Recommendation Report for Planning Permission

REF NO: Y/57/21/PL

LOCATION: Sunnymead
North End Road
Yapton
BN18 0DL

PROPOSAL: Demolition of existing dwelling and outbuildings and erection of 5 dwellings comprising 2 No 4 bed houses & 3 No 3 bed house (resubmission following Y/33/20/PL). This site is in CIL Zone 3 & is CIL Liable as new dwellings. This application is a Departure from the Development Plan.

Birdseye

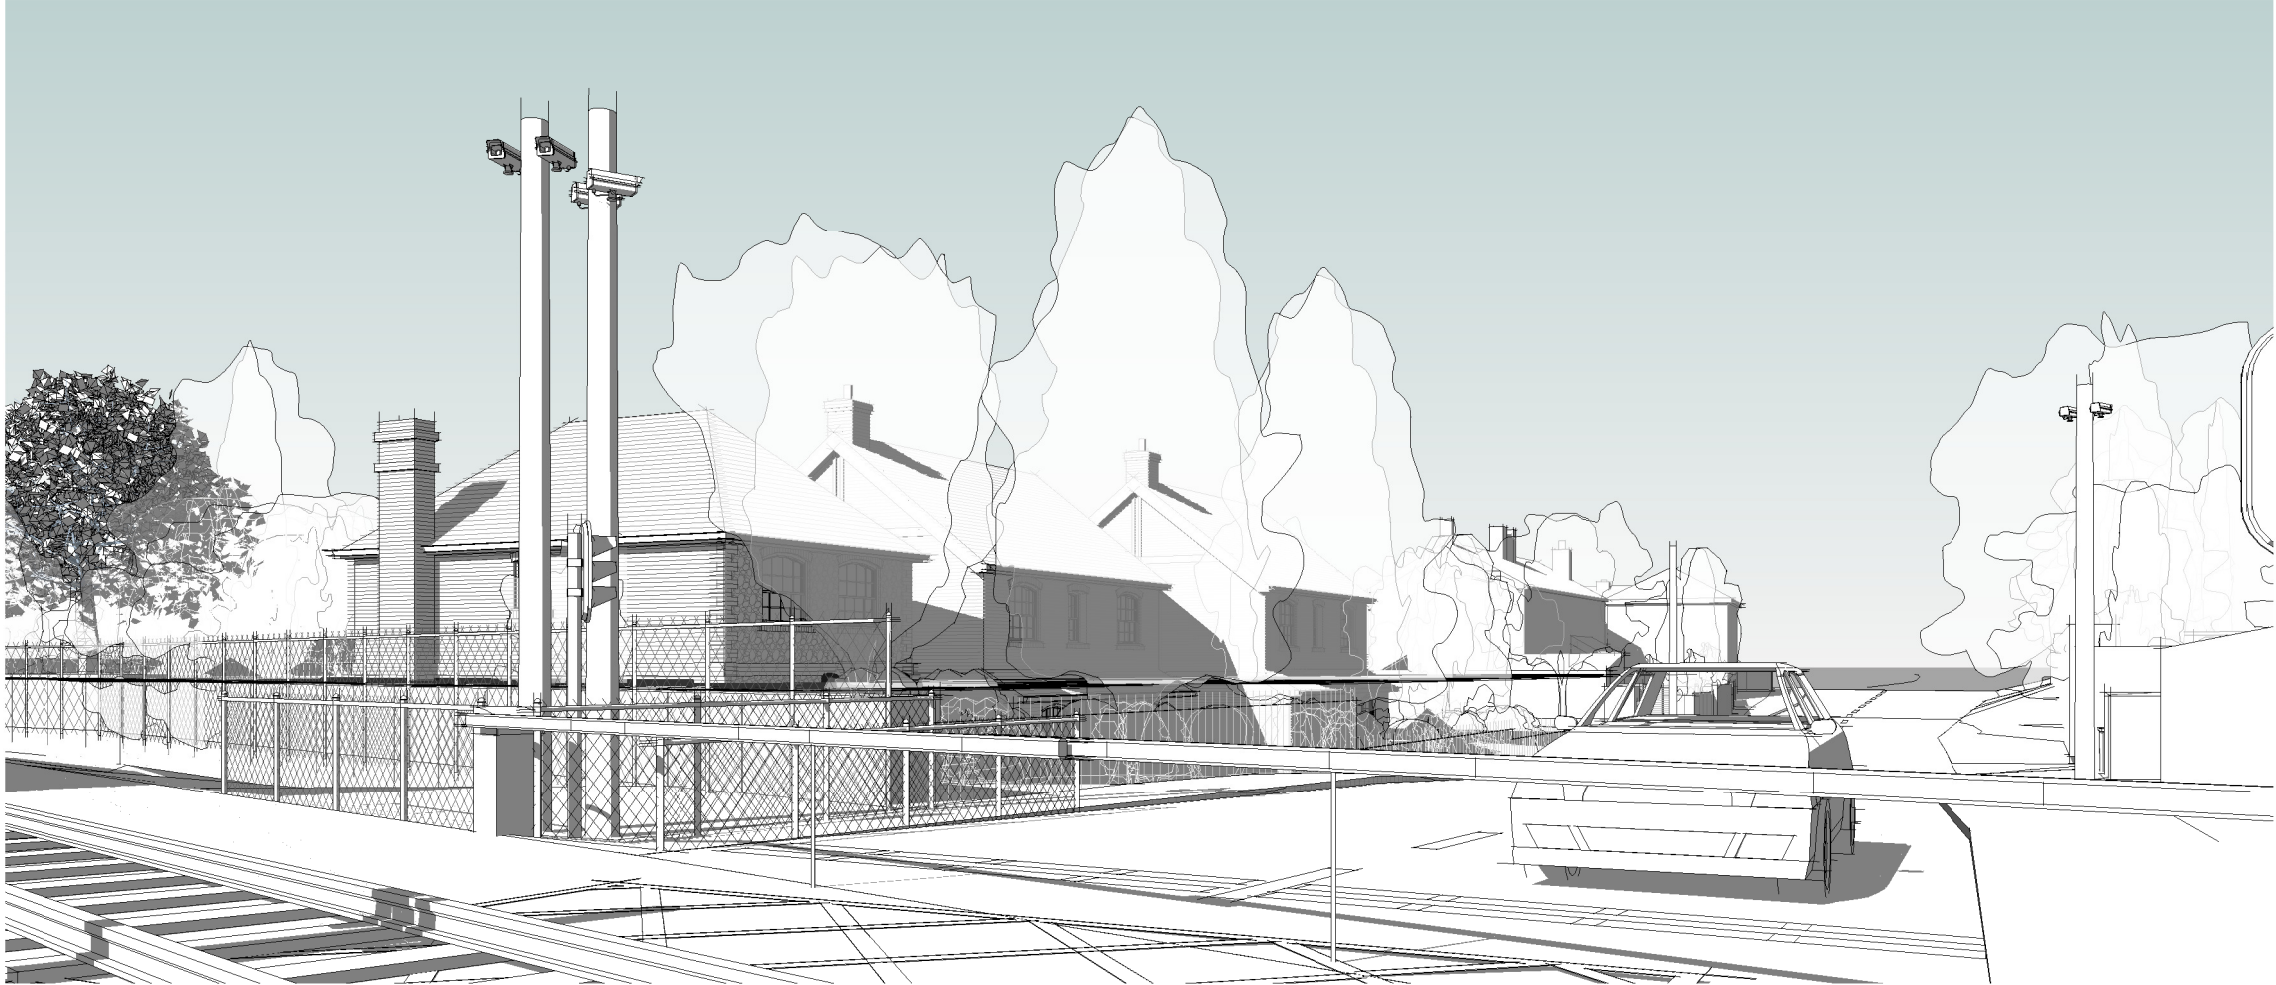
- This will result in flood risk elsewhere and allowing the parking area and rear gardens to flood to up to 0.45m is not safe or sustainable development;
- It is impossible to know if storage can be provided below ground as winter infiltration testing & groundwater monitoring has not been provided;
- The proposed finished floor levels are too low - they should be 300mm above 4.25m AOD (not 4/4.35m as shown on the conceptual drainage strategy drawing in the drainage report);
- No evidence that sequential or exception tests have been carried out; and
- The 3D images do not appear to reflect level changes proposed within the Drainage Strategy Report.

Drawing No.	Rev.
D1958-100	-

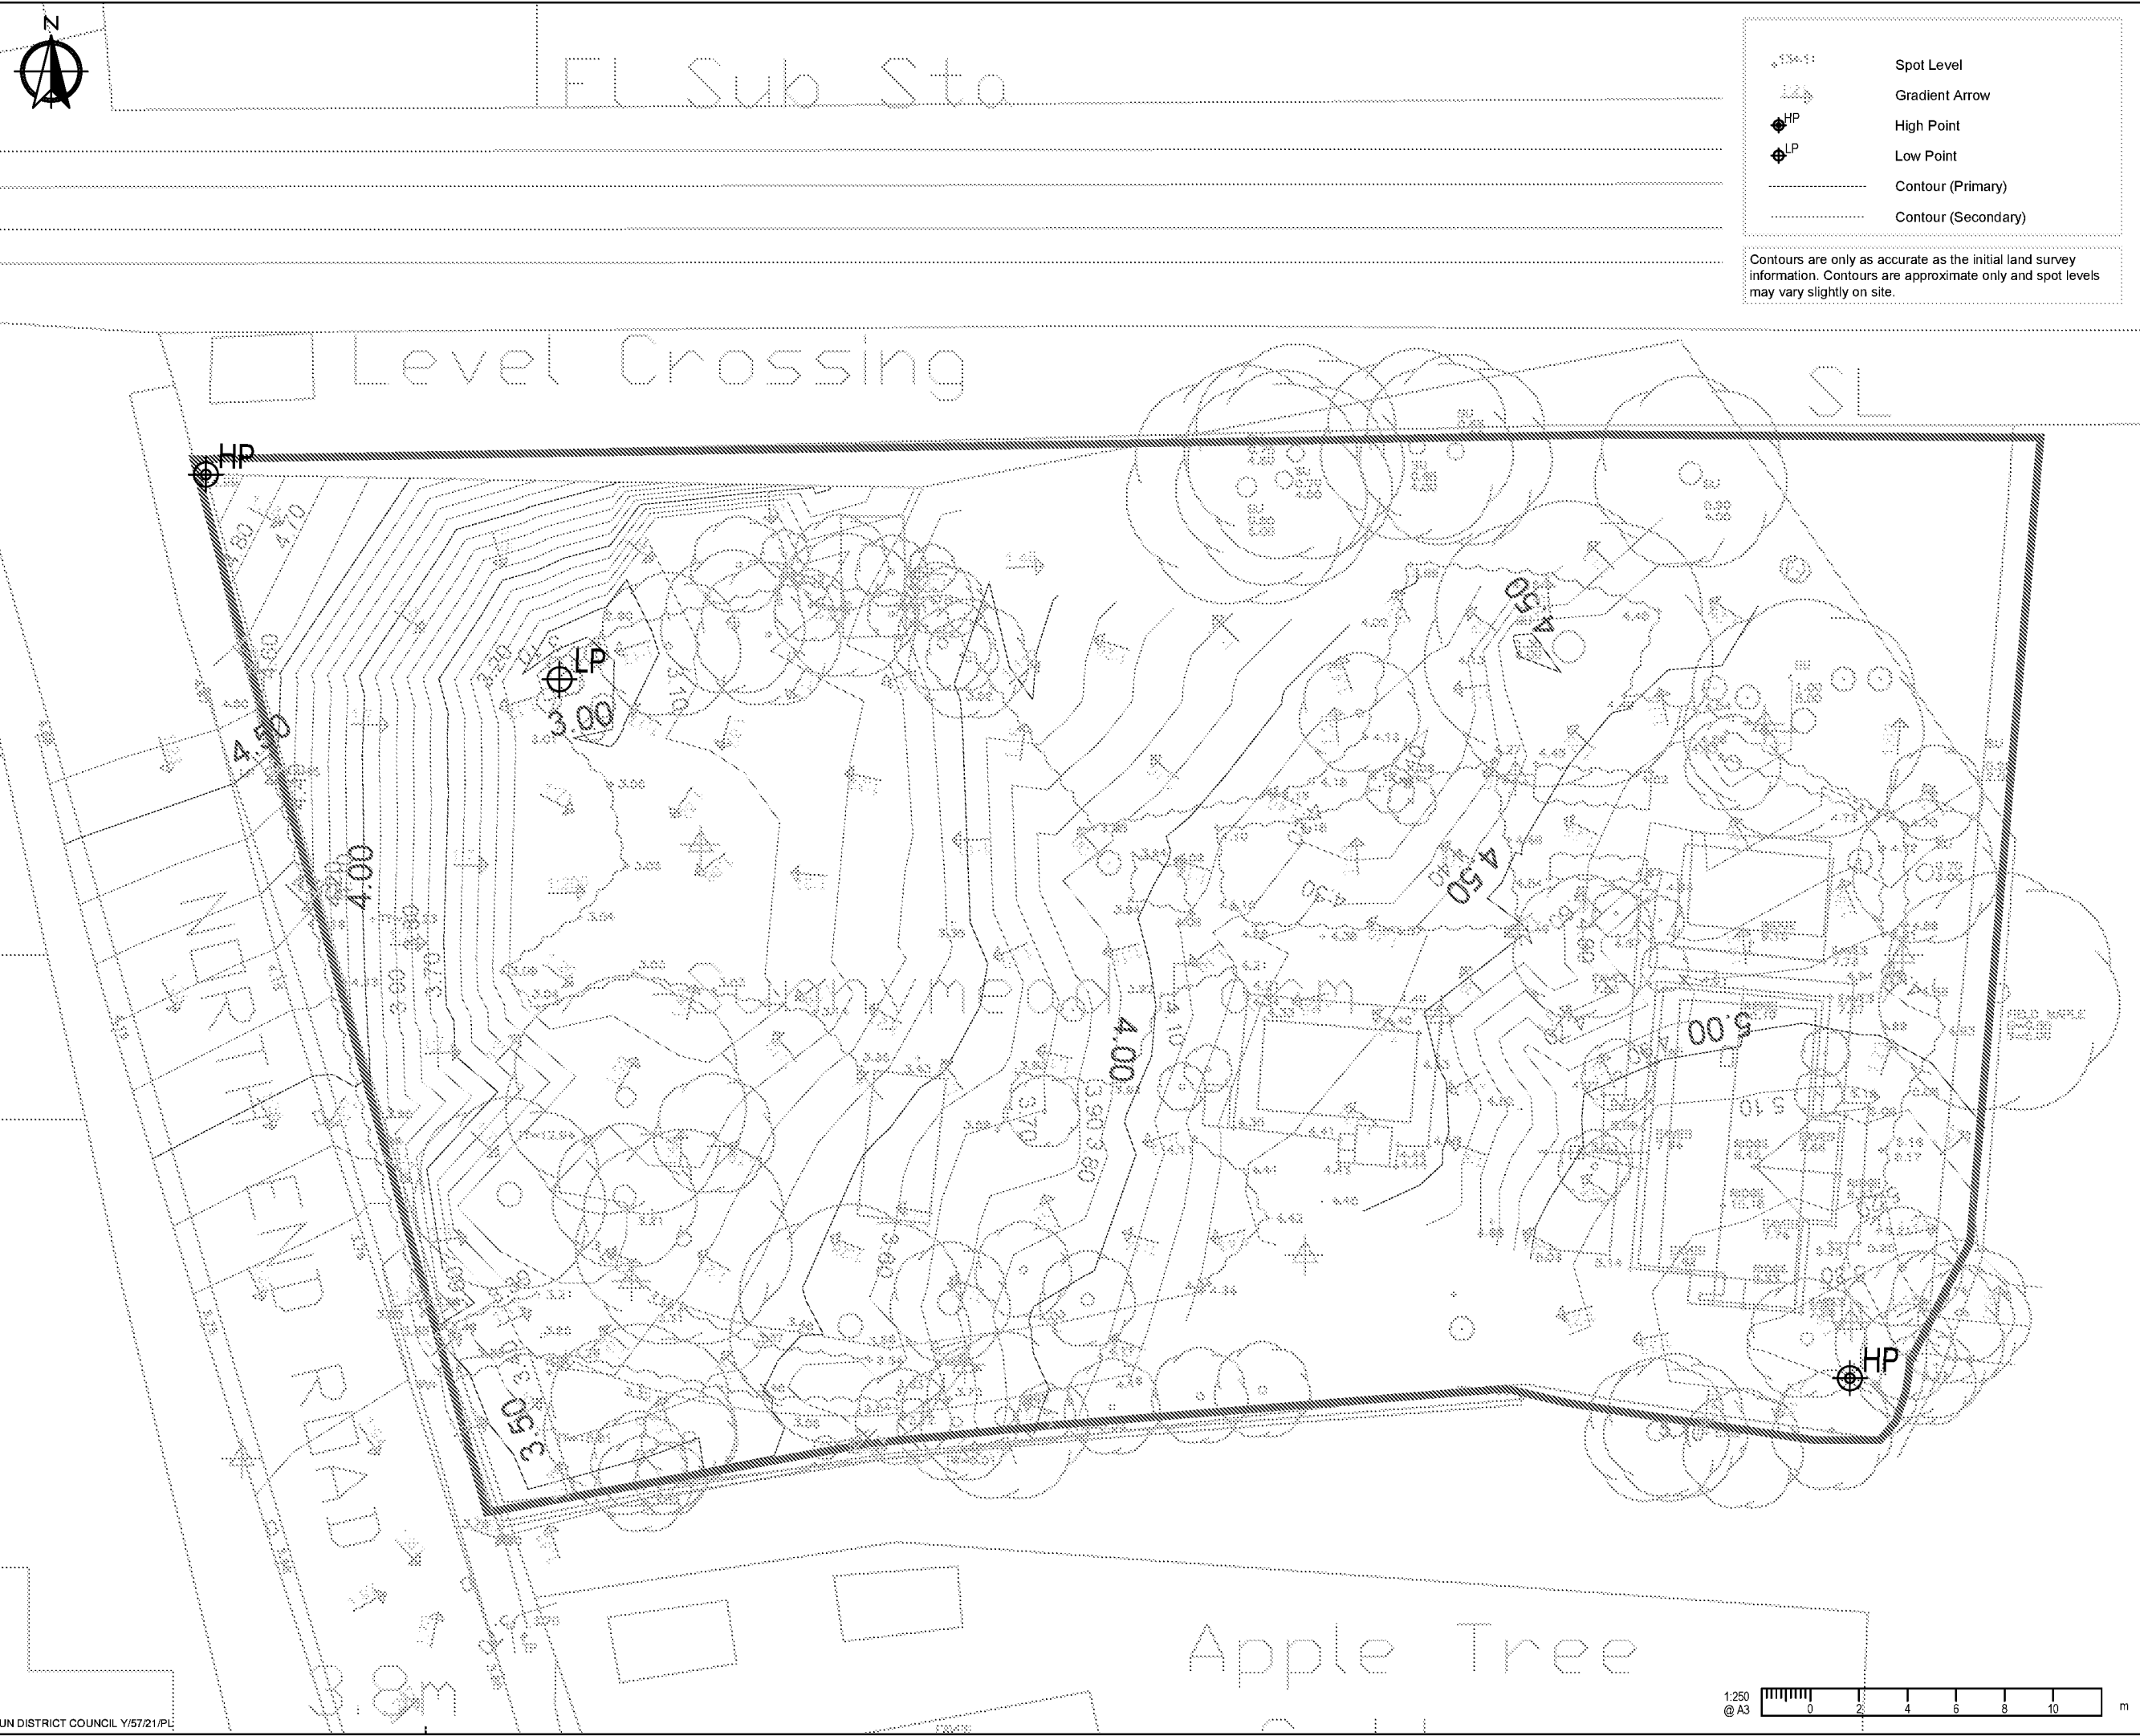
ADC DRAINAGE - objection. The applicant has not satisfactorily addressed previous concerns/refusal reason. The concerns are detailed in the full response on the website (01/07/21) but in summary:

- The three detached dwellings are in a low part of the site (also a low part of the wider area) known for

surface water flooding. To combat this levels are to be raised and flood storage provided in the parking area but this will not be deep enough to store flood water;
